Comments on surface water drainage;

APPLICATION NO: LU/90/20/DOC

Site Address: Land South of Toddington Lane Littlehampton BN17 7PP

Description of Works: Approval of details reserved by condition imposed under ref LU/47/11 relating to Condition Nos 10 - surface water drainage, 13 - foul drainage, 15 - tree protection, 19 - ecology, 20 - ecological management plan, 21 - ecological management plan, 22 - Construction Method Statement, 23 - construction compound, 25 - vehicle & highway cleaning, 31 - decentralised & renewable energy, 37 - noise mitigation and 40 archaeology.

Hydro-Brake Control Chamber HB2

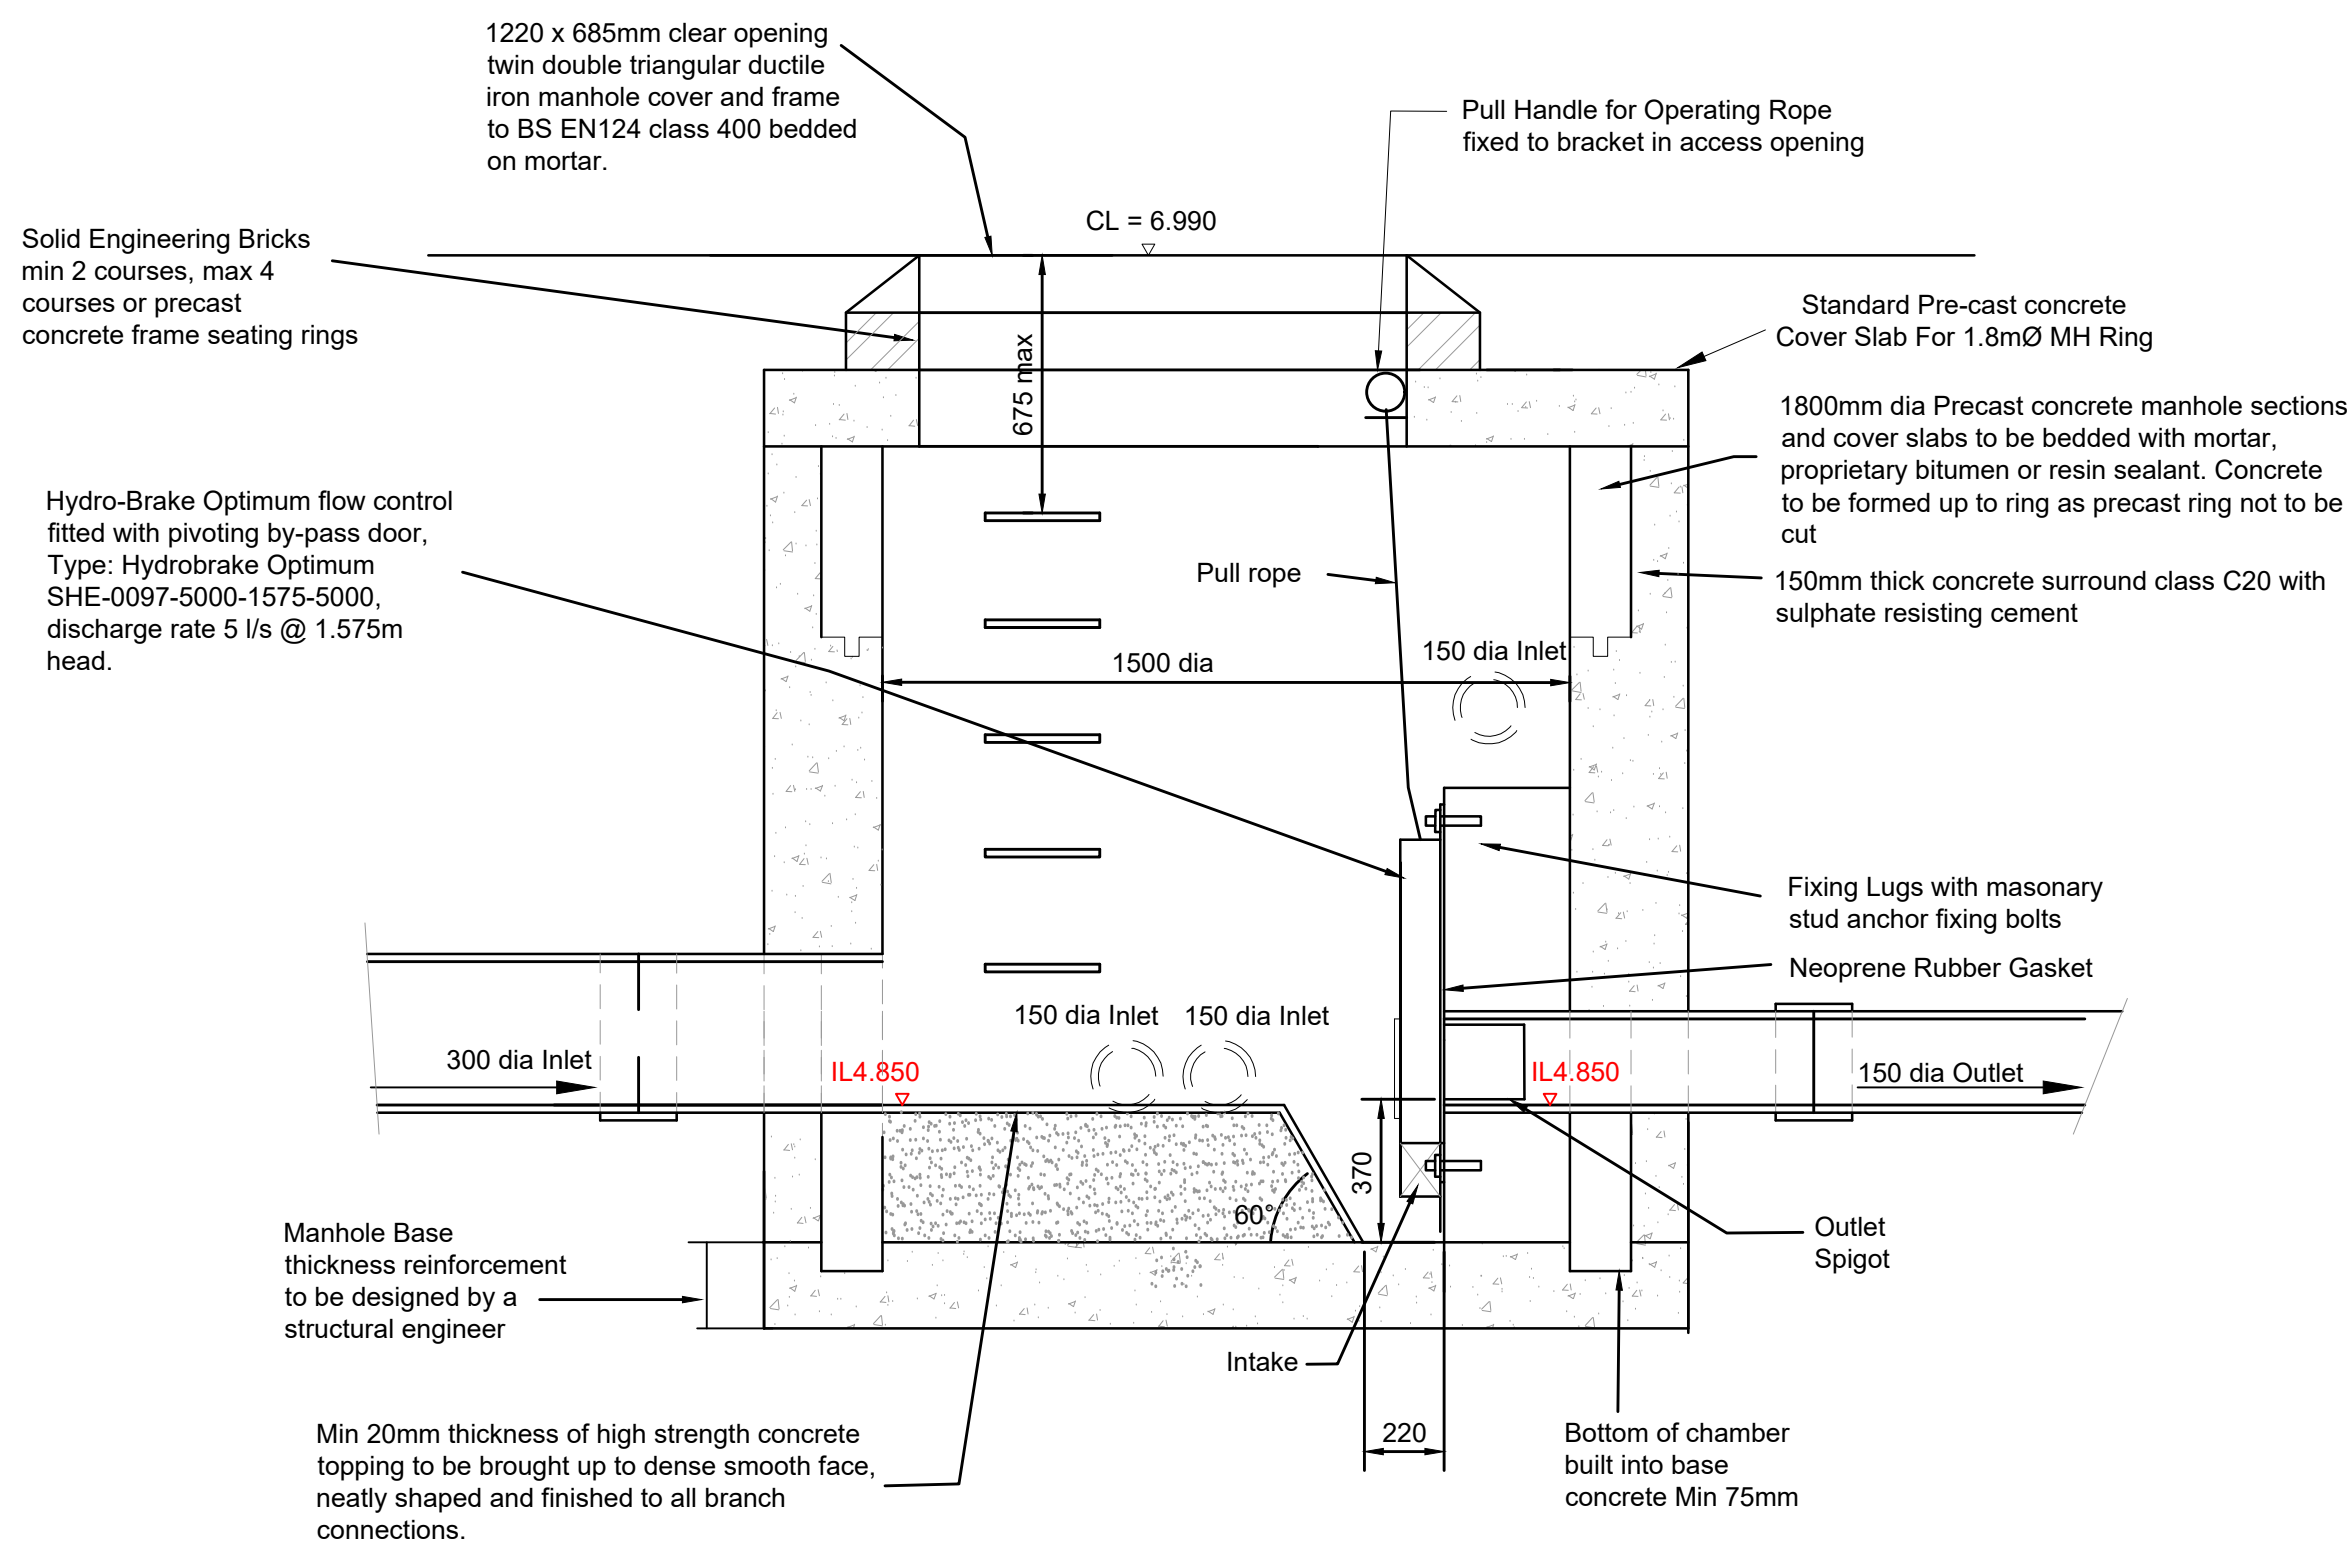
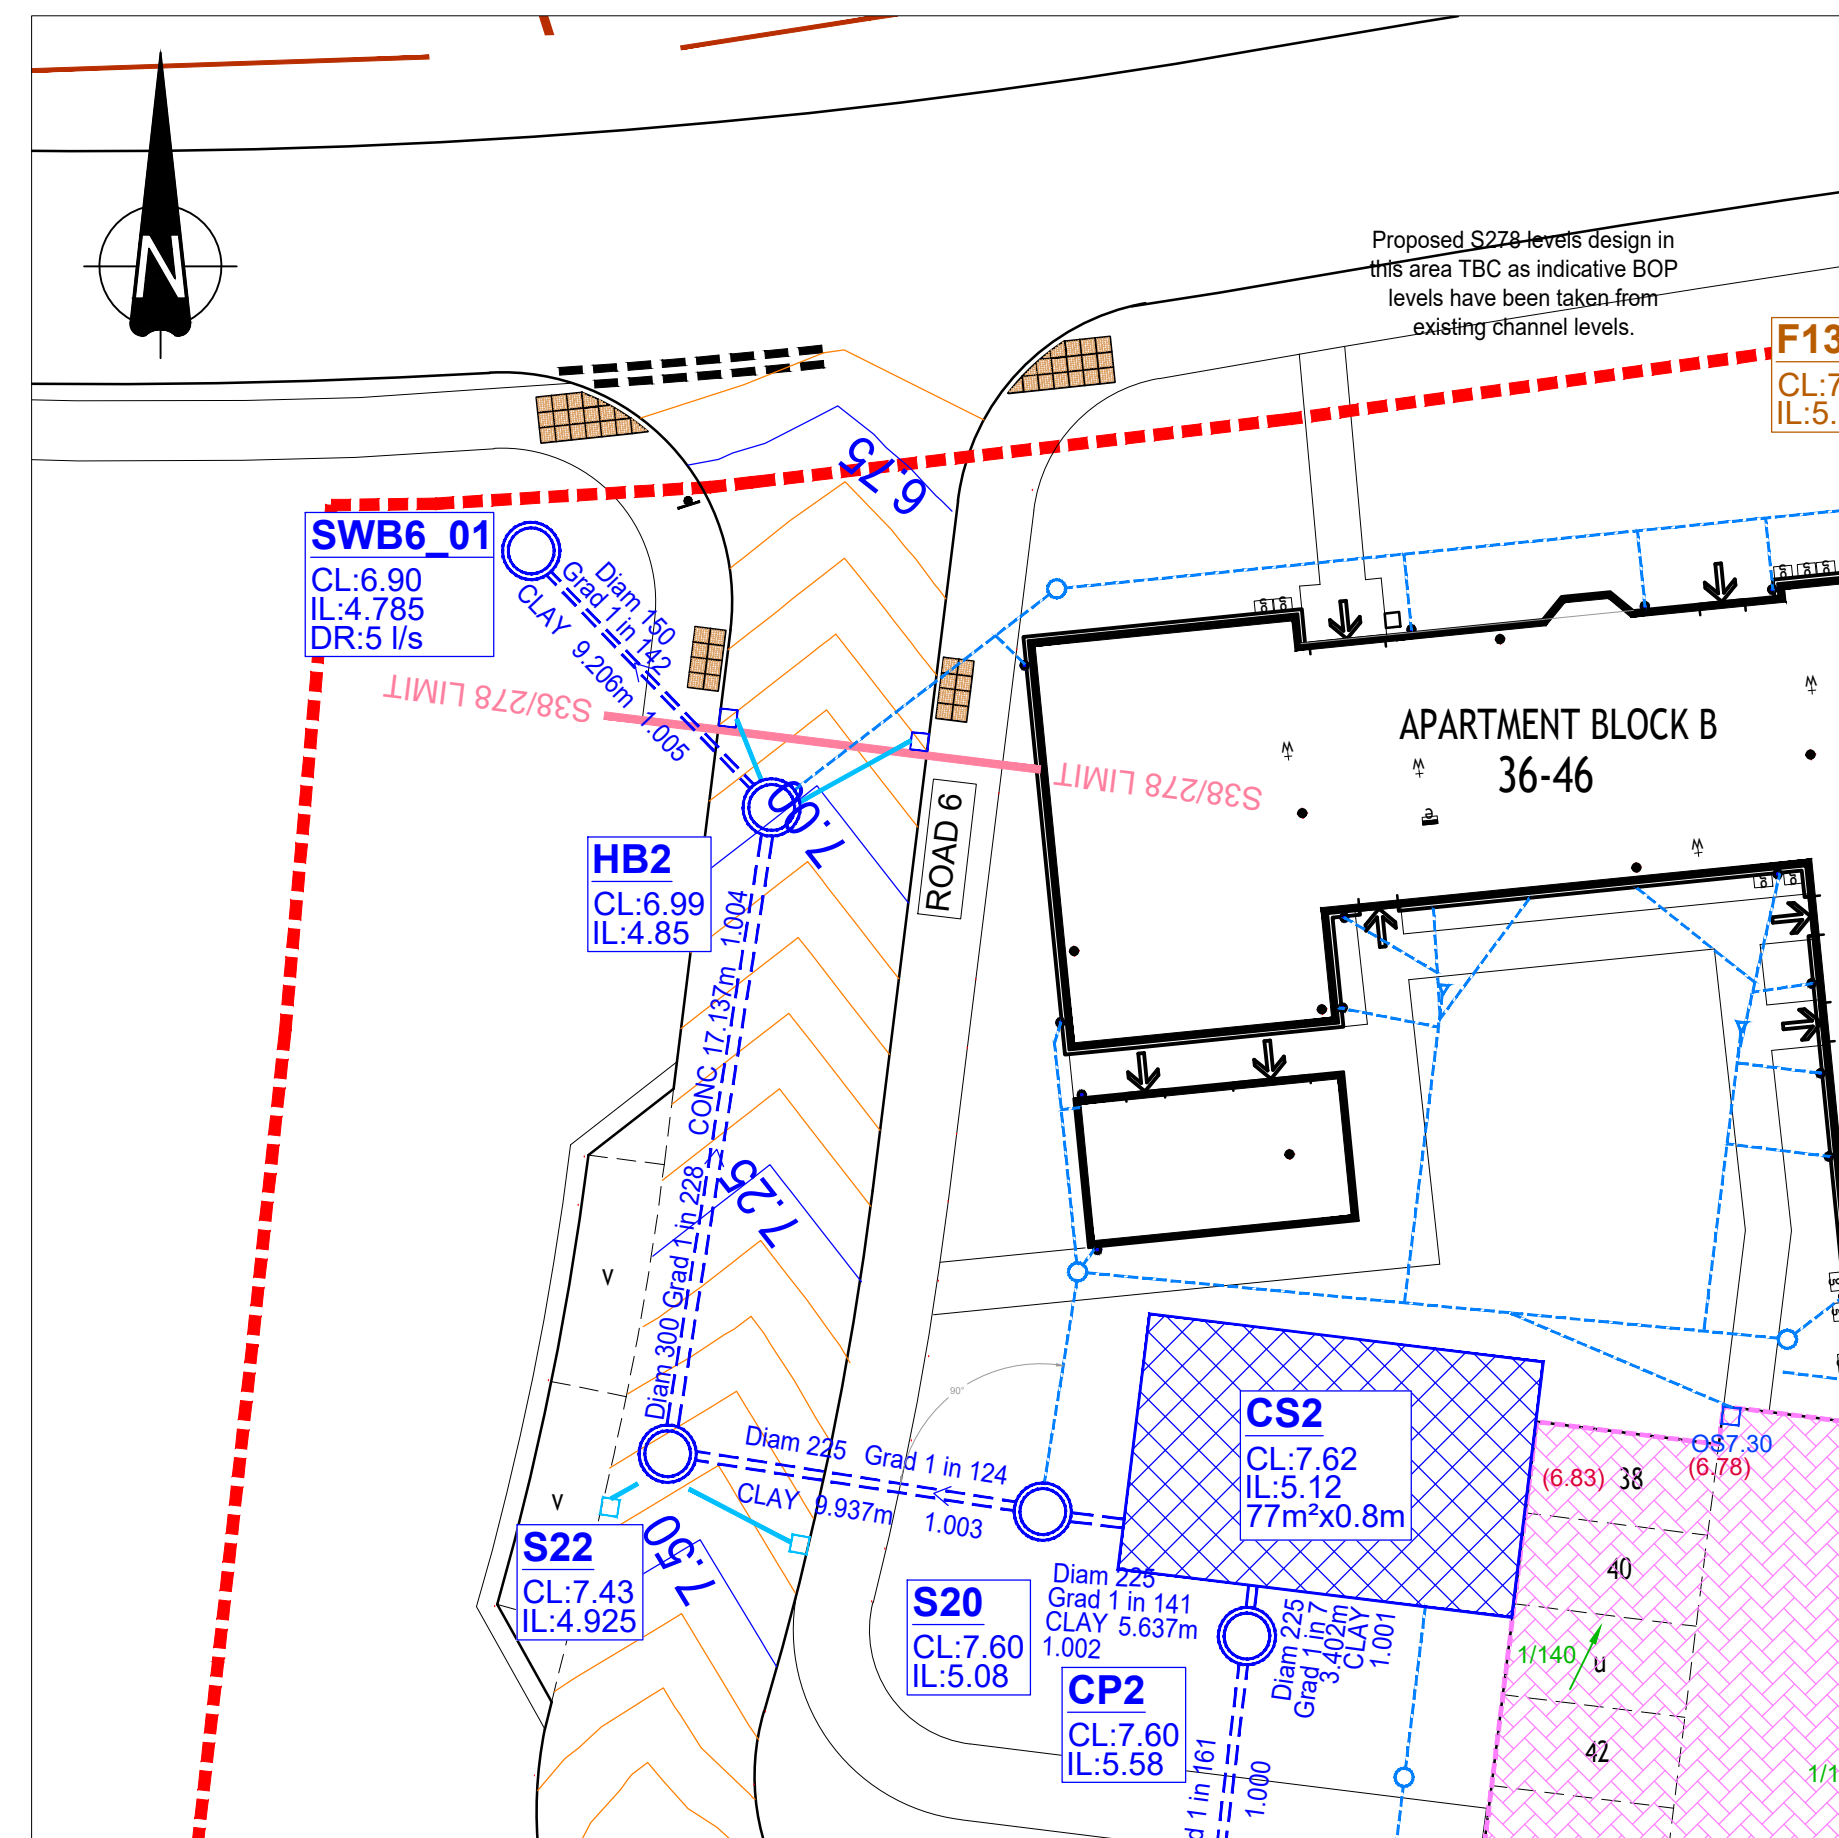
7. Provide fully detailed construction drawings to include manholes including catchpits & hydrobrake chambers, gullies, channel drains, permeable paving and outlet sumps/diffuser unit, storage tanks, rodding eyes, pipe bedding, etc.

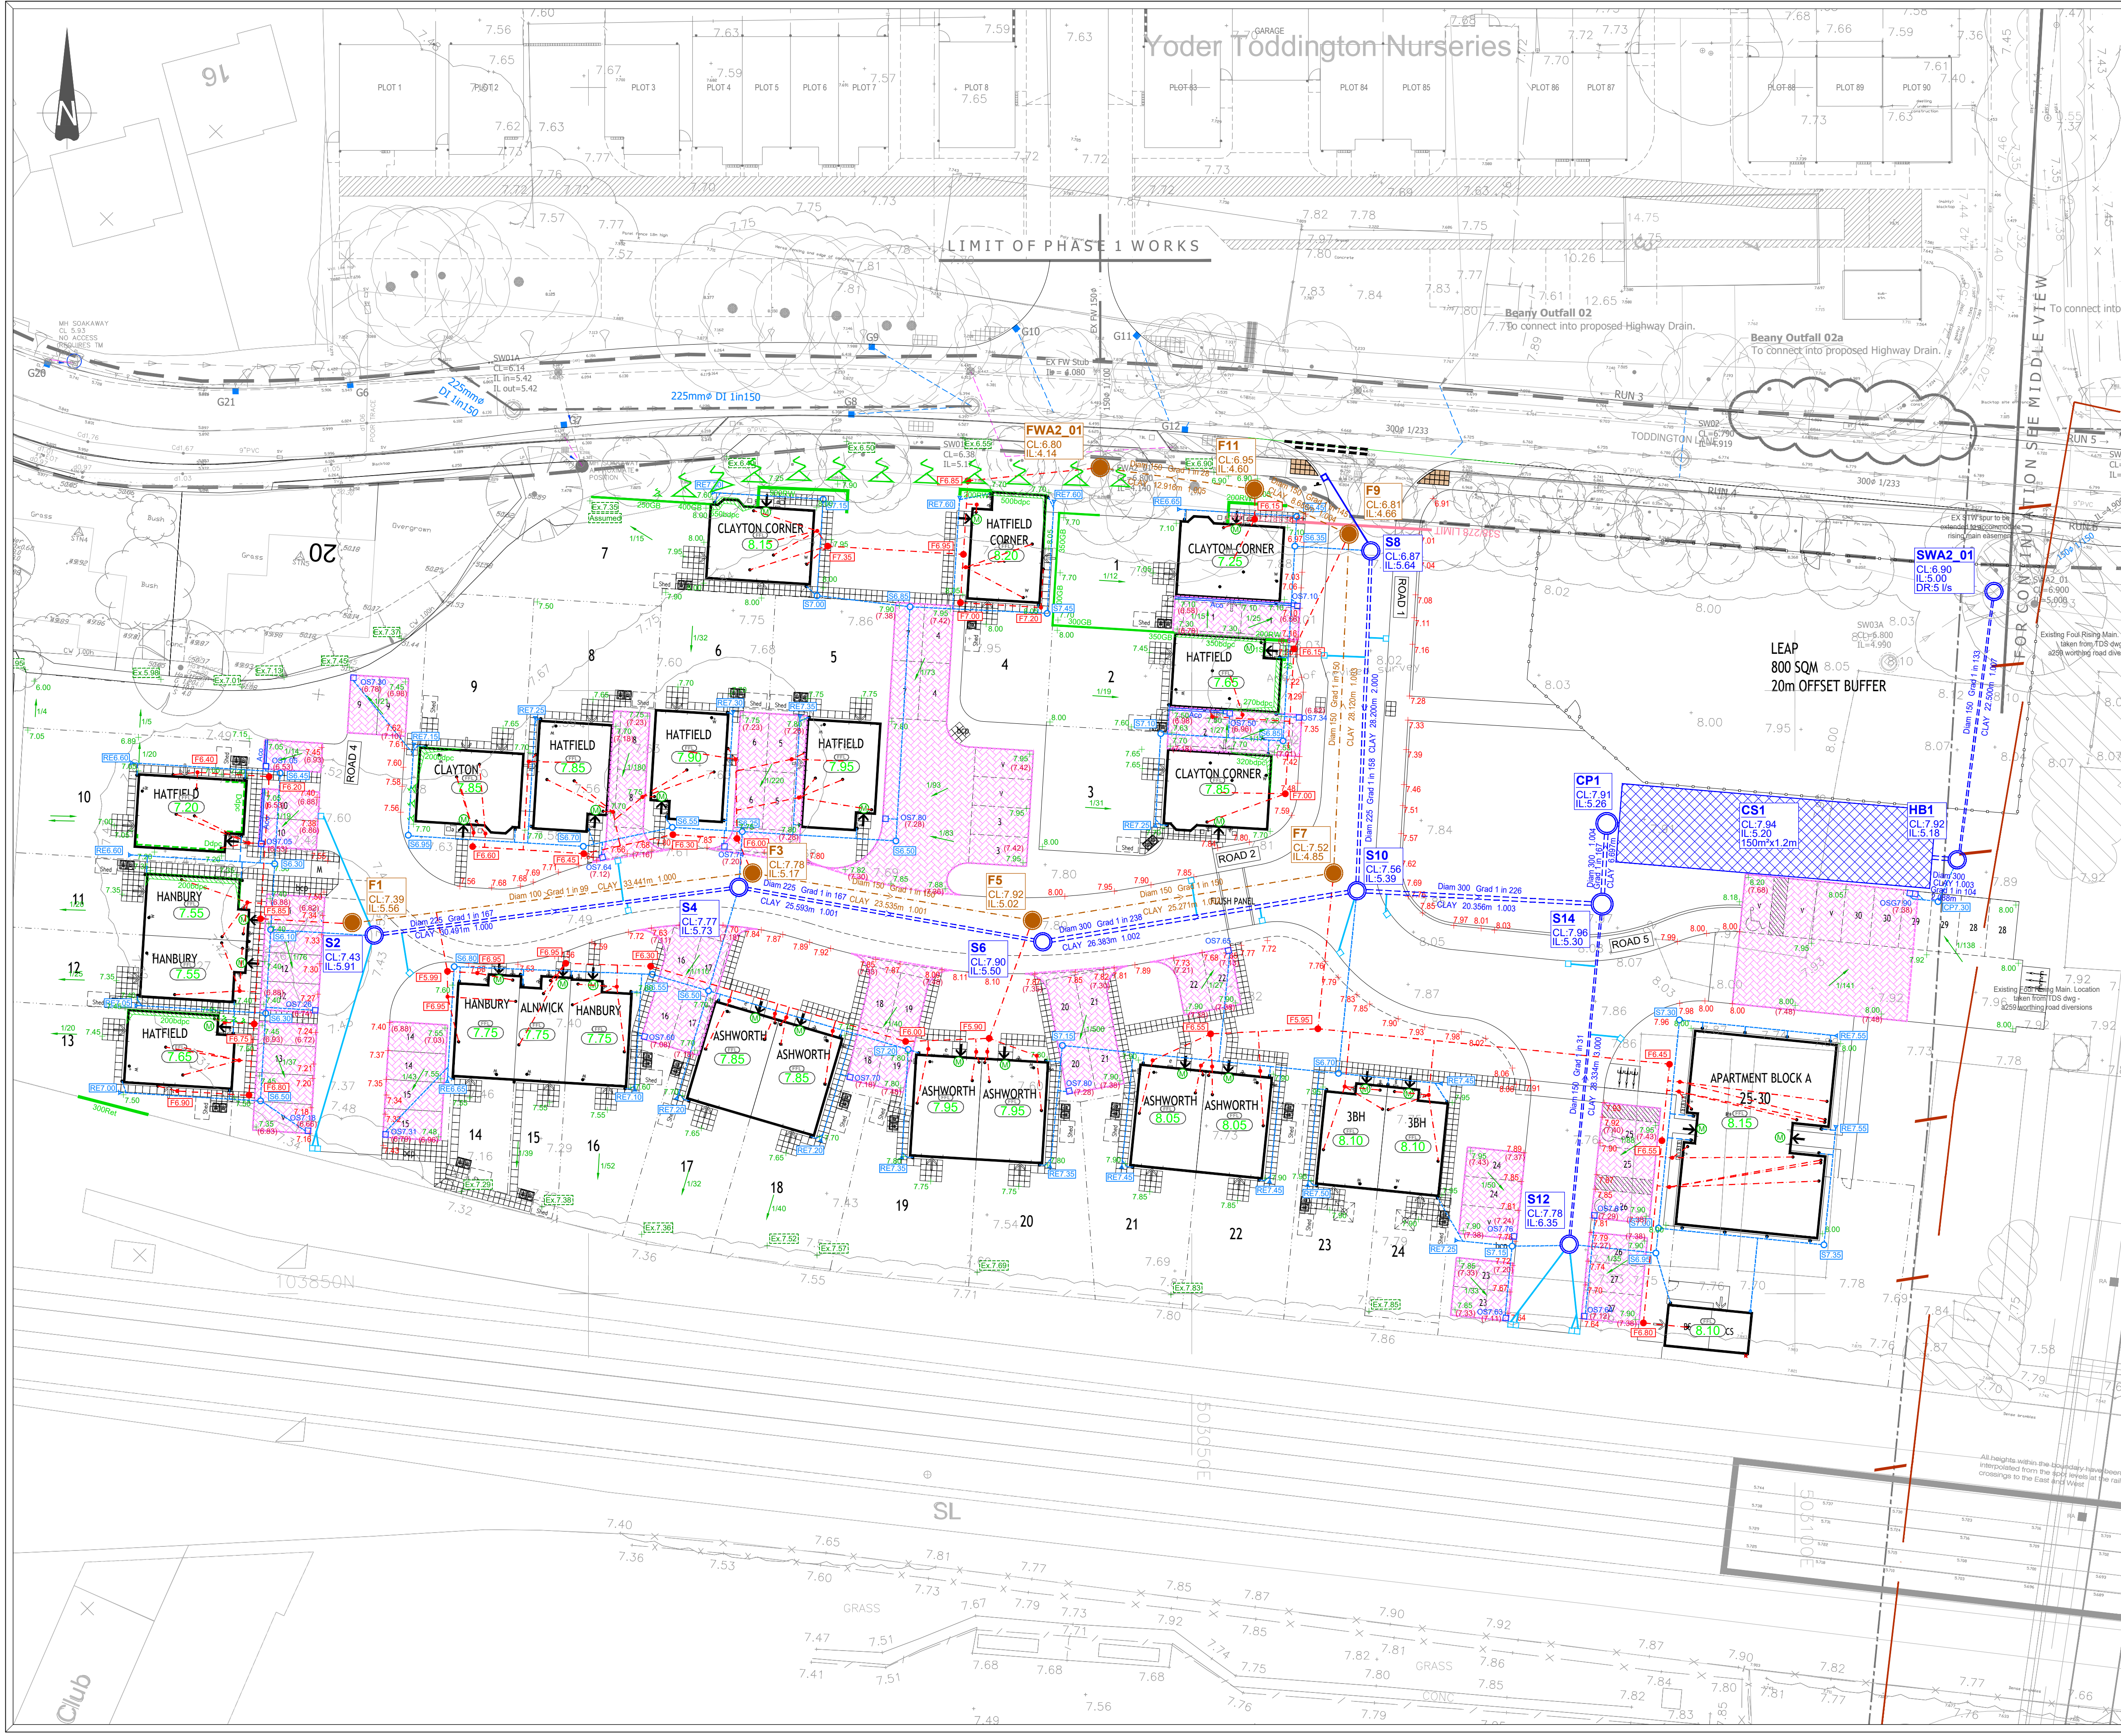
2. Provide groundwater monitoring data.
3. With reference to Southern Waters consultation, listing issues to be addressed, please show the foul rising main on the layout drawing/s.

6. Provide hydraulic calculations to confirm that the 1 in 100 year storm event (+40% allowance for climate change) can be stored within the system/on site.

12. Add note that all pipes are to be connected soffit to soffit. Where pipes of differing diameters are connecting to one another, show the connecting invert level.

13. Where connections are not being made to manholes, the oblique 45 degree junctions are to be used. Add note.
14. Pipes connecting to the 900mm oversized pipe must connect at soffit to soffit level not invert to invert. Can the storage tank be increased in size to remove the need for the 900mm pipe?

15. Can the CS2 tank be made online rather than offline?
16. Gully north of HB2 control chamber is connecting against the flow. Reconfigure the arrangements here to improve the situation.

17. Western spur – provide diameter/levels/gradient.
18. Gullies downstream of S8 – stagger connections so not opposite one another.
19. Alter colour of permeable paving outline ie. not blue, in order to avoid confusion.

20. Specify manhole S18 as a catchpit.
21. Rather than running pipes under the permeable paving, can they be connected into the paving via diffuser units?
